70013258 -FRA Addendum P01

DATE:	11 June 2024	CONFIDENTIALITY:	Public
SUBJECT:	WSP Response to LLFA comments		
PROJECT:	Land East of Westergate, Aldingbourne. Ref 70013258	AUTHOR:	Julien Blavignac
CHECKED:	Luke Beeching	APPROVED:	Luke Beeching

WSP RESPONSE TO LLFA COMMENTS

This addendum has been prepared in response to comments raised in the objection submitted by West Sussex County Council Lead Local Flood Authority (LLFA) dated 3rd of April 2024 in relation to the Flood Risk Assessment and Drainage Strategy issued as part of the outline planning application AL/11/24/OUT - Land East of Westergate, Westergate.

SCALE 1:1000	DRAWN	APPROVED
PROJECT NO. 70013258	DESIGNED	LRB
	PN	PN
	DATE	June 24
LAW-WSP-ZZ-ZZ-CDR-05000		
P03		
© WSP UK Ltd

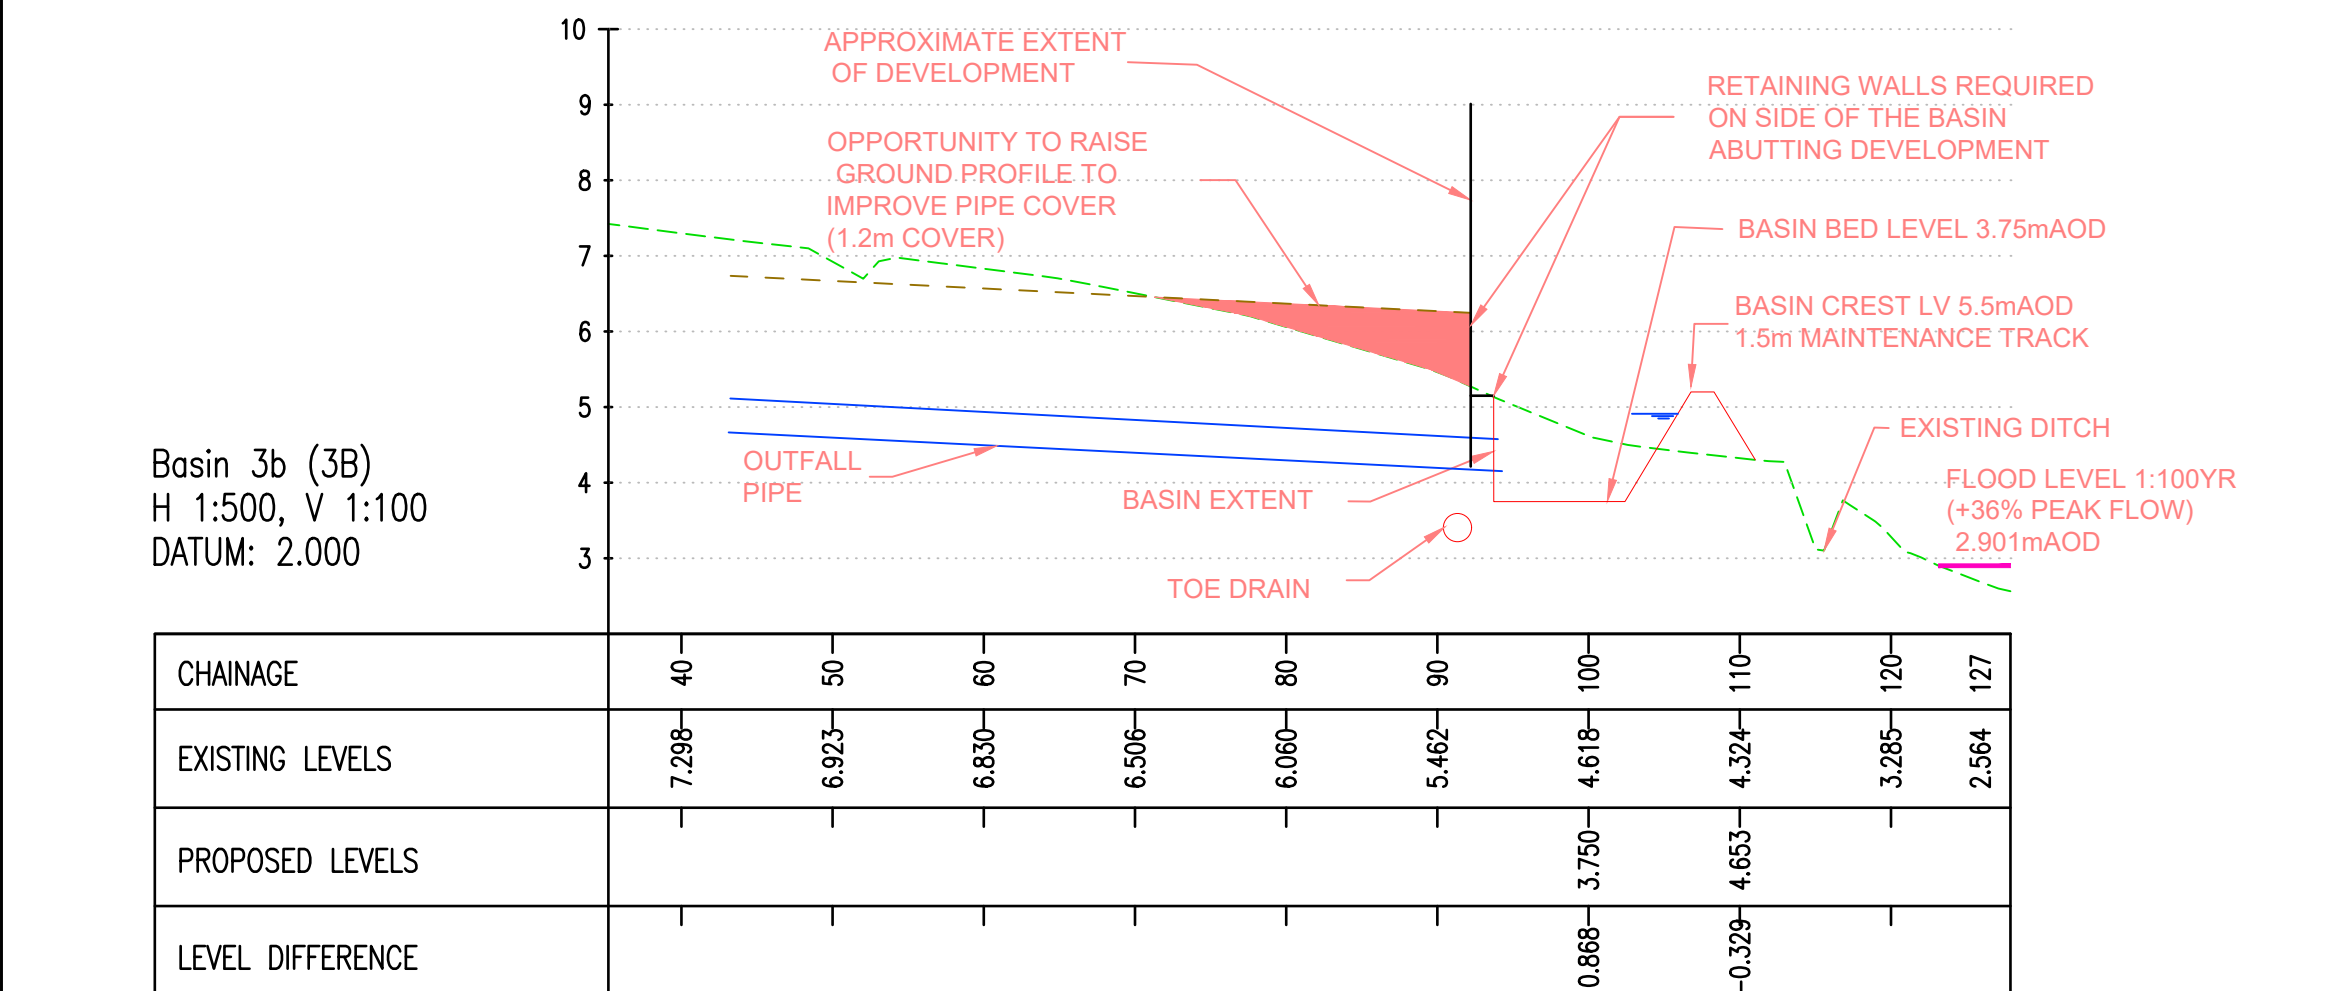
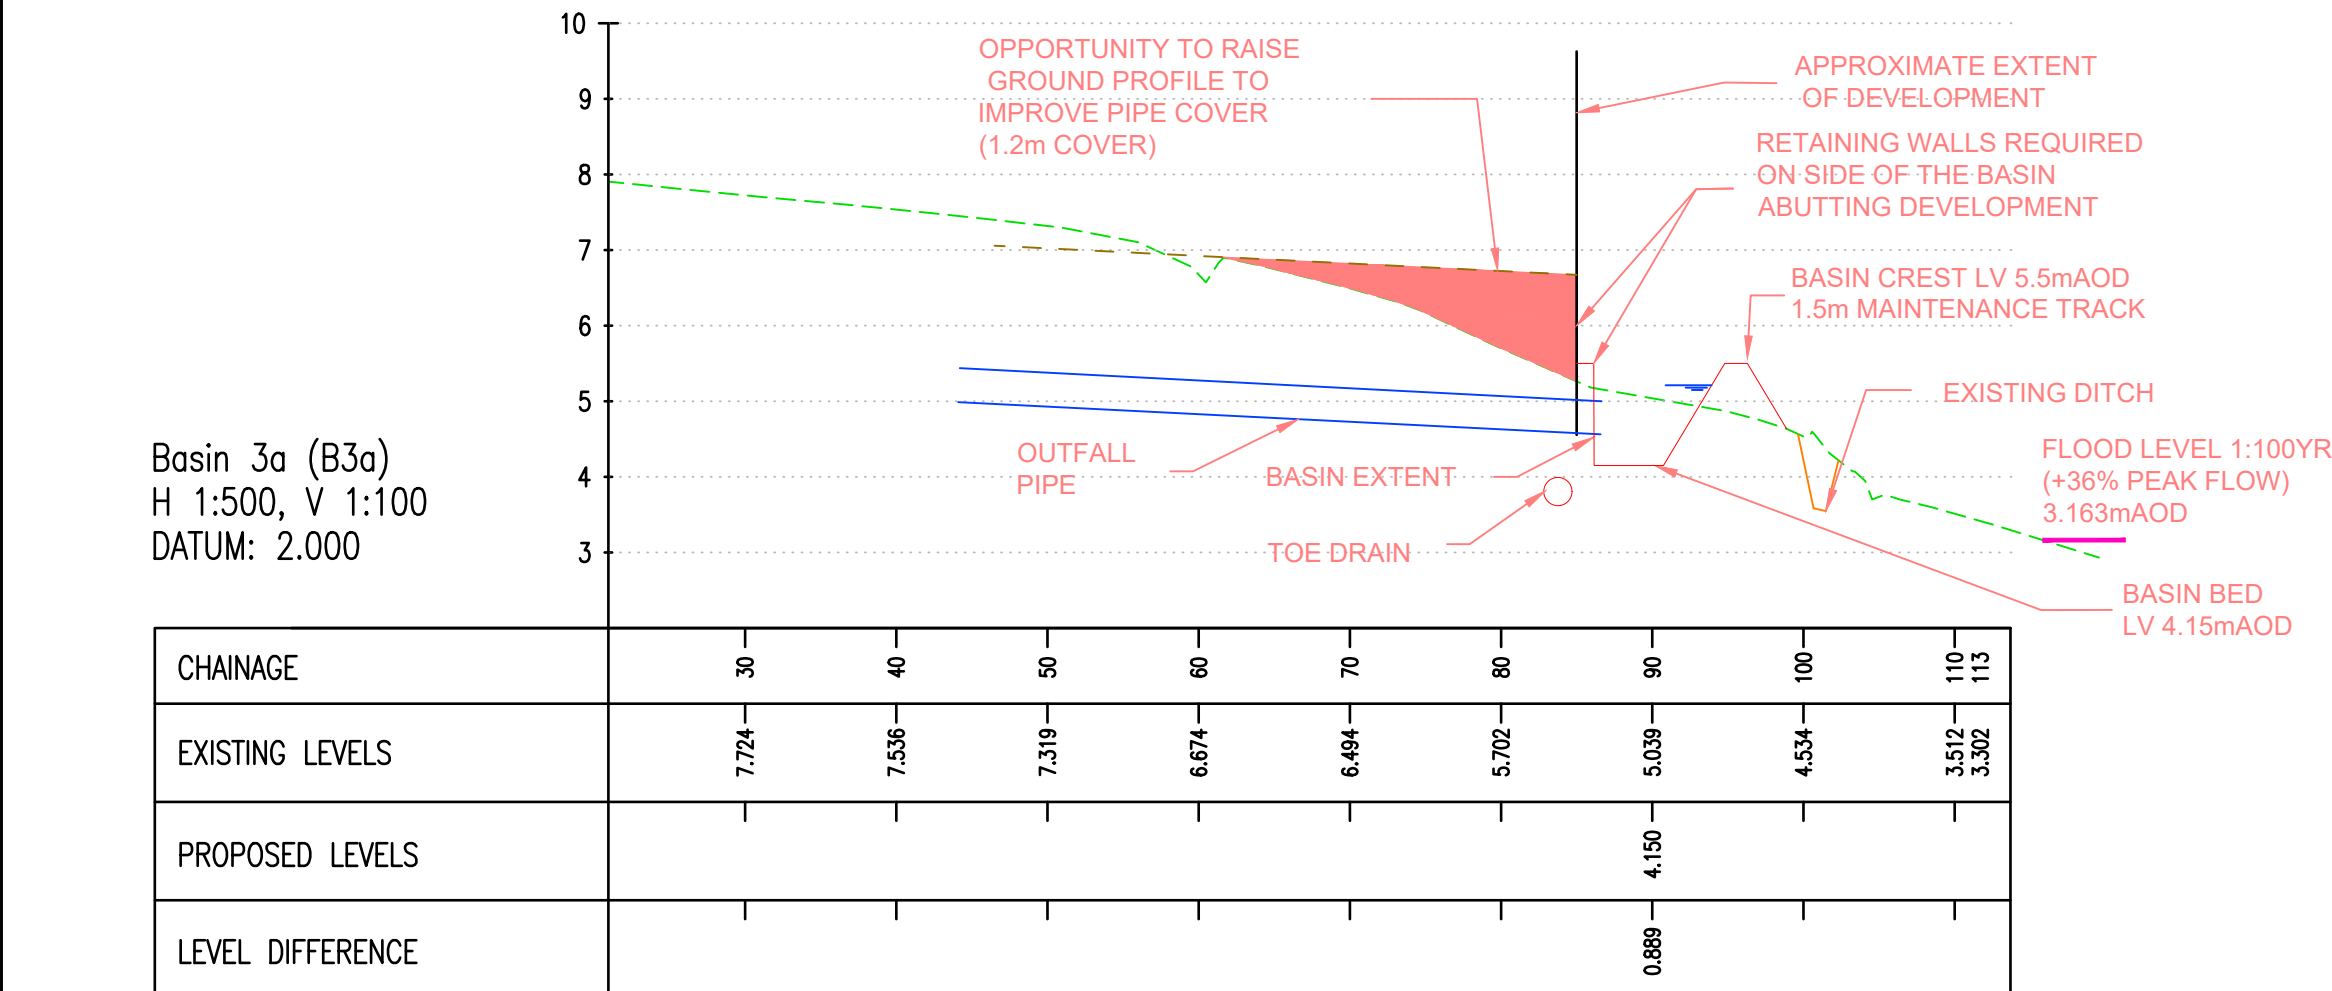
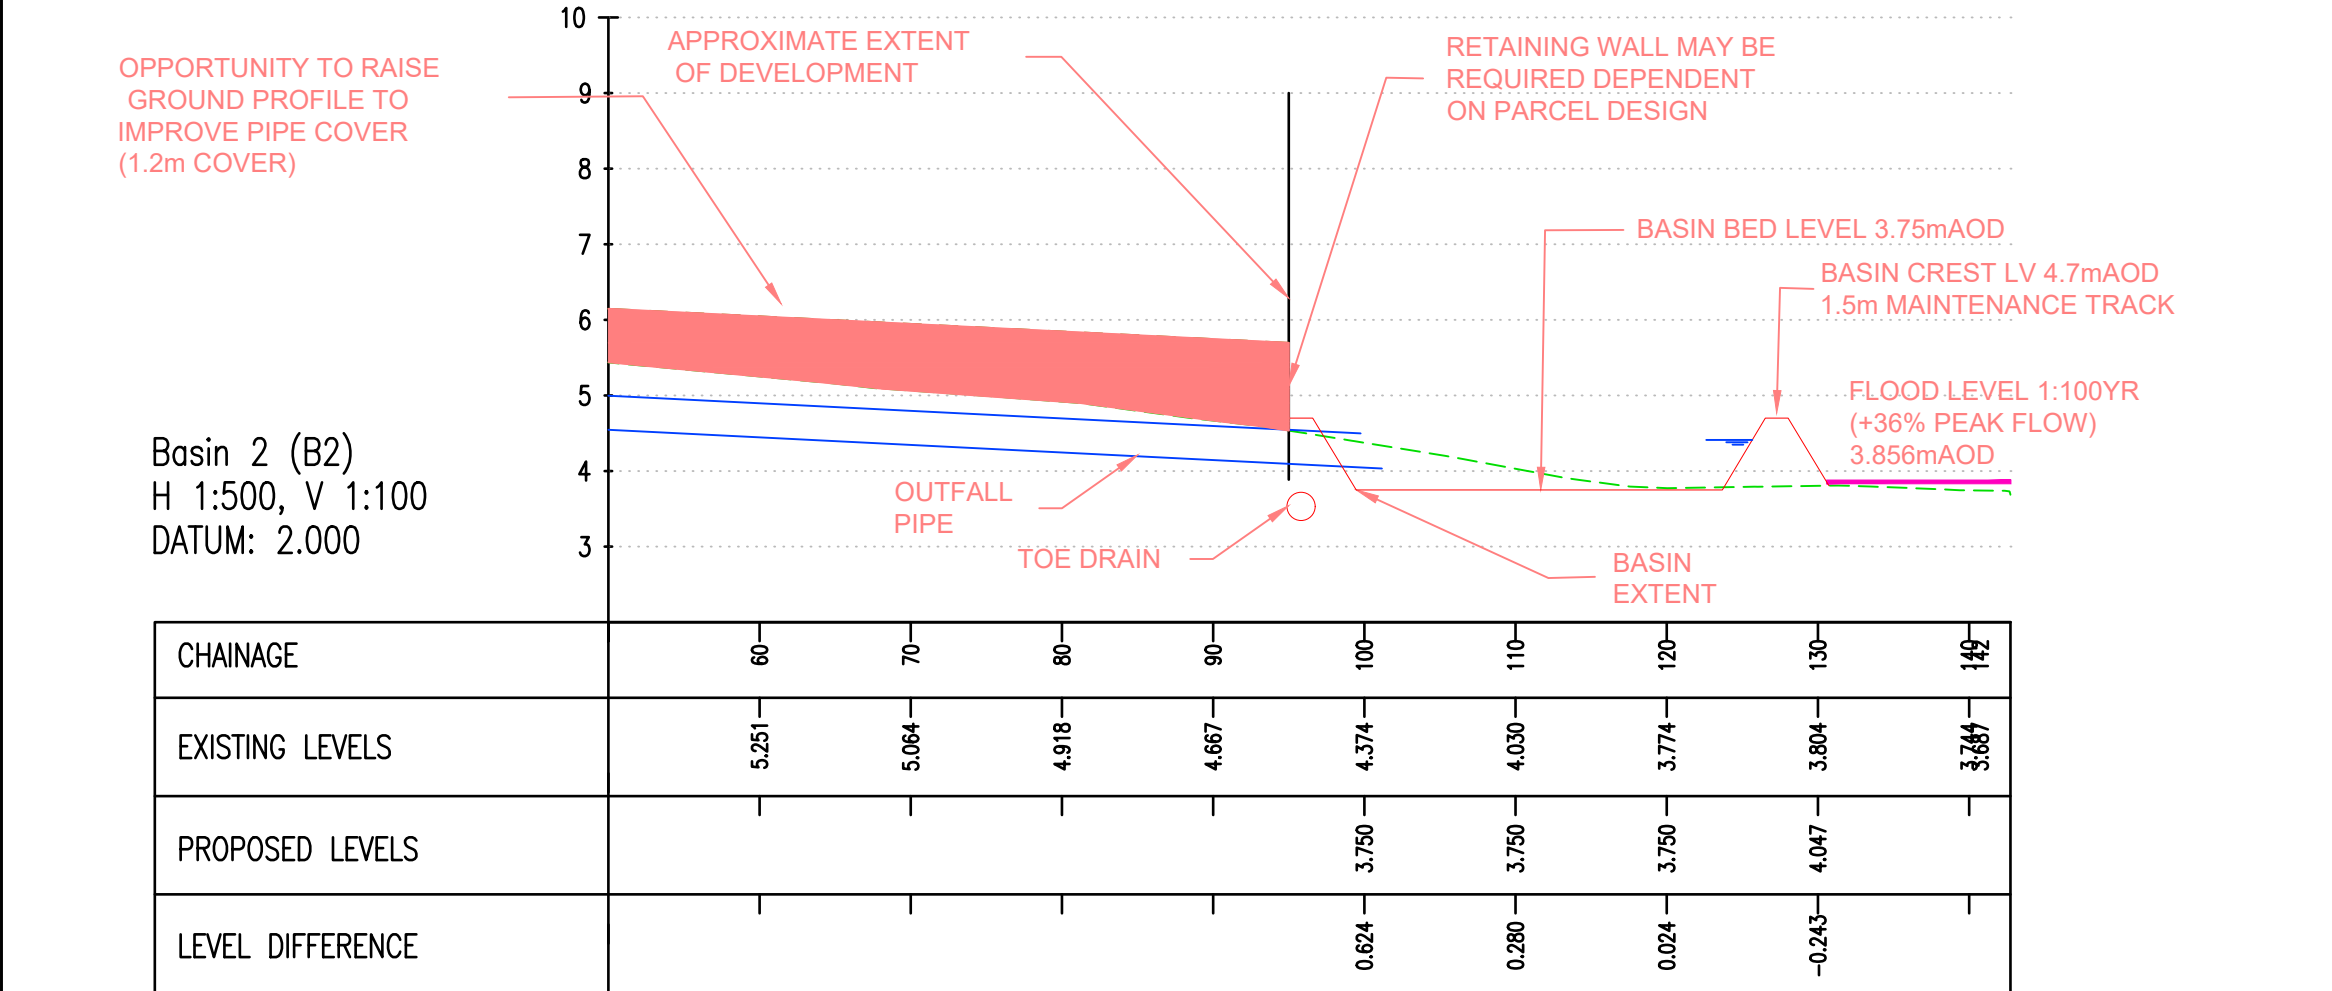
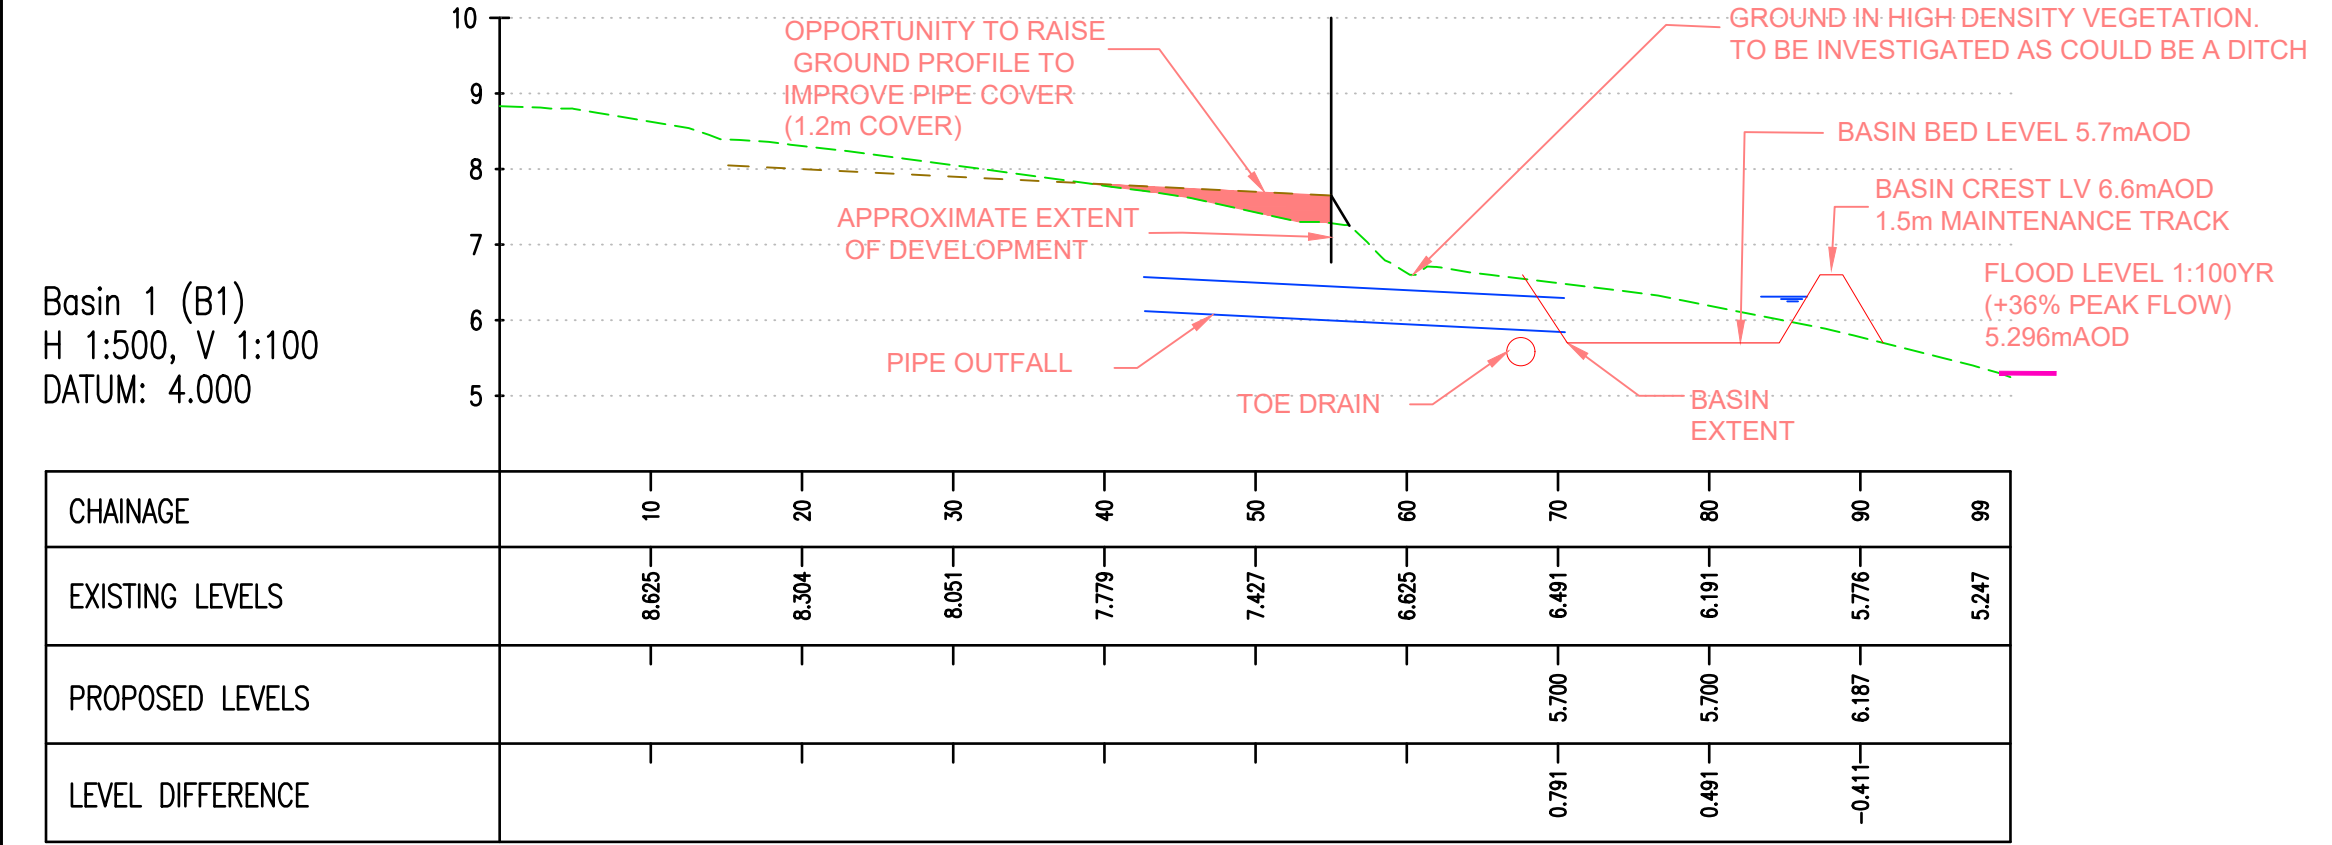
2.Outline drainage modelling calculations should be resubmitted and demonstrate how 10% urban creep has been included in the volume of SuDS storage required.

4. For ordinary watercourses and SuDS features there should be a 3m easement on drawings and 8m for main rivers unless otherwise agreed with the EA who are responsible for main rivers.

5.The impact of ground raising on surface water flow paths should be considered, to ensure surface water flood risk is not increased elsewhere.

A copy of the updated SuDS Storage Estimate which includes allowance for urban creep is included in Appendix A and is also summarised on drainage strategy drawing ref. LAW-WSP-XX-XX-C-DR-0500 updated to revision P03 and included in Appendix C.

WSP Response: These offsets have been added to drawing LAW-WSP- XX-XX-C-DR-0500 included in Appendix C.

Please note that the 3m offset shown around the Basins has been drawn from the base of the external raised embankment (where the basin is in fill) on the lower side and from the crest of the basin on the upper side (where the basin is in cut) basin embankment. The basins allow for a 1.5m maintenance track

A 8m offset is shown from the top of the river banks, identified from the topographical survey prepared for the site.

WSP Response: Expected overland flow directions have been added to drawing LAW-WSP- XX-XX-C-DR-0500 included in Appendix C. Based on the understanding of the existing gradients on site and the strategic locations of the SuDS Basins, it is anticipated that levels on site will allow for overland flow to be directed toward the basins and river / watercourses. Levels are in general intended to follow existing topography with localised level increases to reduce gradients on the eastern edge of the parcels.
